Attachment A Response to Submissions

Horsley Drive Business Park Stage 2 – Building 1
State Significant Development Application
SSD 10404

Submitted to Department of Planning &
Environment
On behalf of Charter Hall

25 June 2020 | 2190880

Figure 8 Overall Site Plan

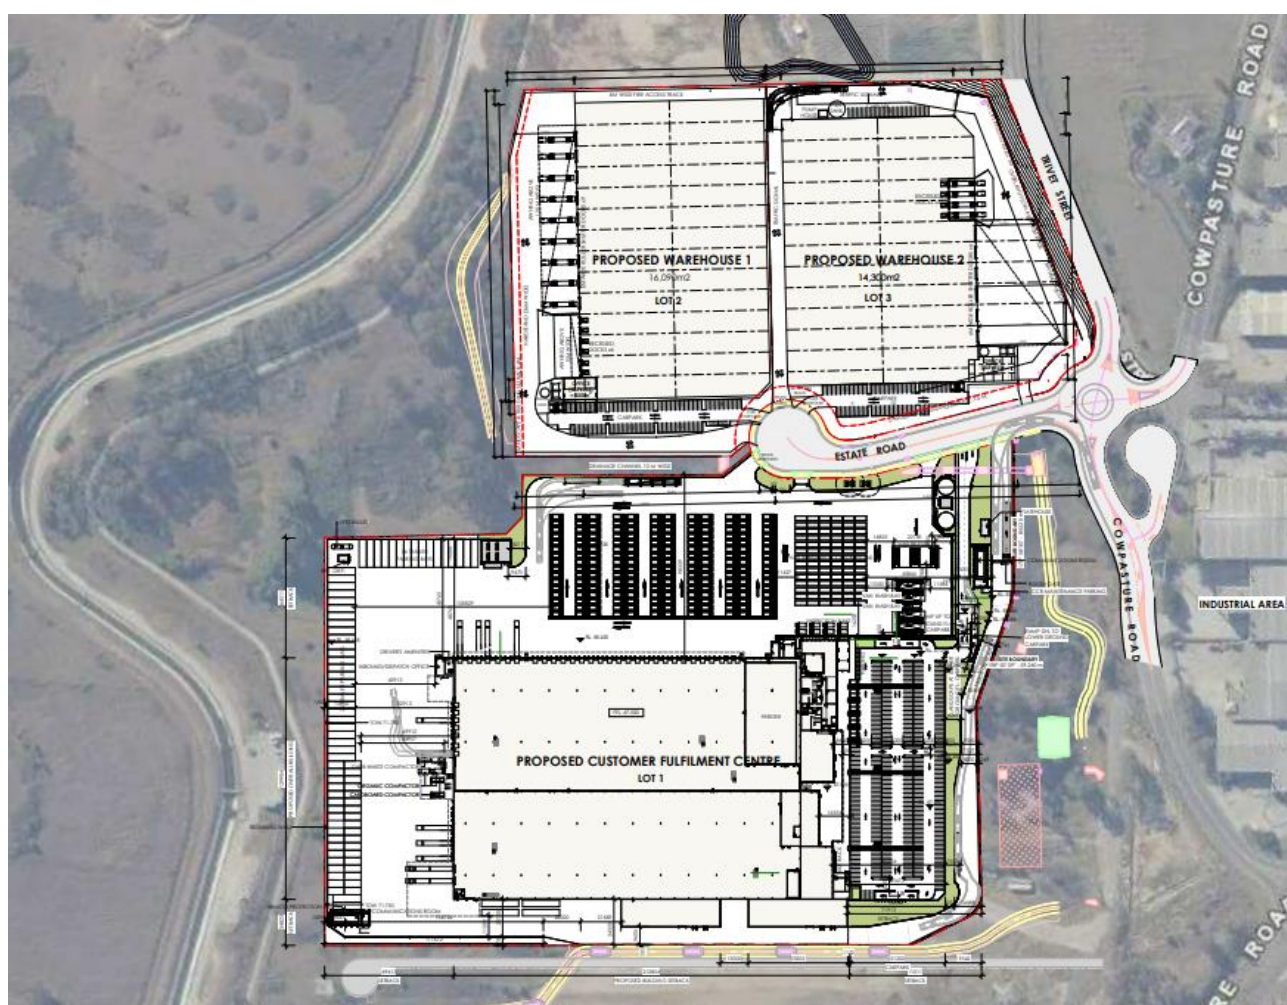
| Issues Raised by Agencies and Organisations | Proponent's Response |
|---|--|
| <i>Confirm the location of the diesel storage.</i> | <ul style="list-style-type: none"> The diesel storage is proposed in a packaged fuel tank/dispensing facility nominated as "Van Re-fuel" on the overall site plan (DA 020). Please refer to the Architectural plans attached at Appendix B. |
